STATE OF NORTH CAROLINA  
DEPARTMENT OF TRANSPORTATION

**Addendum No. 1**

RE: Contract # C204167  
WBS # 2018CPT.05.23.20321.1, Etc  
STATE FUNDED  
**Durham County**  
51 Sections Of Secondary Roads

**May 15, 2018 Letting**

TYPICAL SECTION 5
RESURFACE S9.5B

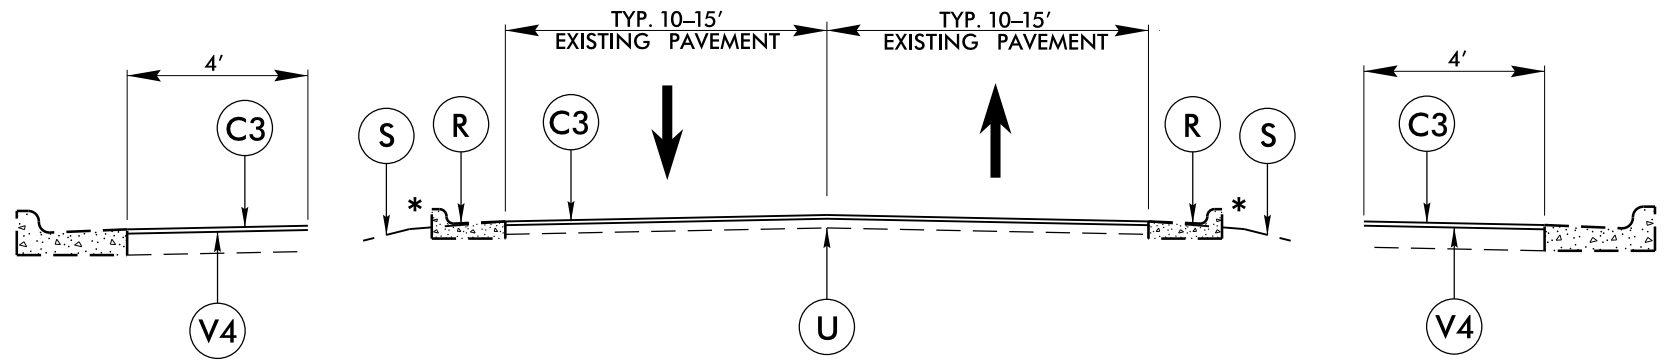
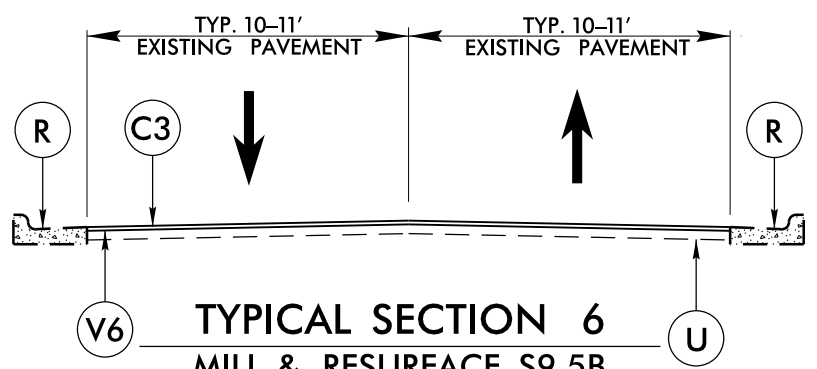
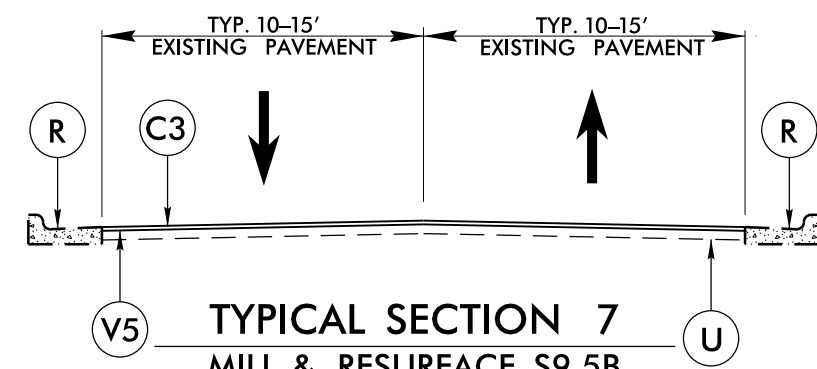
Sheet No.	Revisions
8	Revised "Typical 1" to change the required mix type to S9.5C
13	Revised the "Summary of Quantities" to reflect the change on Typical 1 from S9.5B mix to S9.5C mix

C1	PROP. APPROX. 1" ASPHALT CONCRETE SURFACE COURSE, TYPE S4.75A, AT AN AVERAGE RATE OF 100 LBS. PER SQ. YD.	S	SHOULDER GRADING, ASB REQUIRED (EXCEPT AT RESIDENTIAL AREAS)	V4	MILL ASPHALT PAVEMENT, 0-1½" DEPTH
C2	PROP. APPROX. 1" ASPHALT CONCRETE SURFACE COURSE, TYPE S9.5B AT AN AVERAGE RATE OF 110 LBS. PER SQ. YD.	U	EXISTING PAVEMENT	V5	MILL ASPHALT PAVEMENT, 0-3" DEPTH
C3	PROP. APPROX. 1 ½" ASPHALT CONCRETE SURFACE COURSE, TYPE S9.5B AT AN AVERAGE RATE OF 165 LBS. PER SQ. YD.	V1	MILL ASPHALT PAVEMENT, 1" DEPTH	V6	MILL ASPHALT PAVEMENT, 0-5½" DEPTH
C4	PROP. APPROX. 2" ASPHALT CONCRETE SURFACE COURSE, TYPE S9.5C AT AN AVERAGE RATE OF 112 LBS. PER SQ. YD.	V2	MILL ASPHALT PAVEMENT, 1½" DEPTH	V7	MILL ASPHALT PAVEMENT, 3" DEPTH
R	EXISTING CURB AND GUTTER	V3	MILL ASPHALT PAVEMENT, 2" DEPTH	* VARIABLE OUTSIDE SHOULDER – PARTIAL C&G, PARTIAL EARTH SHOULDER
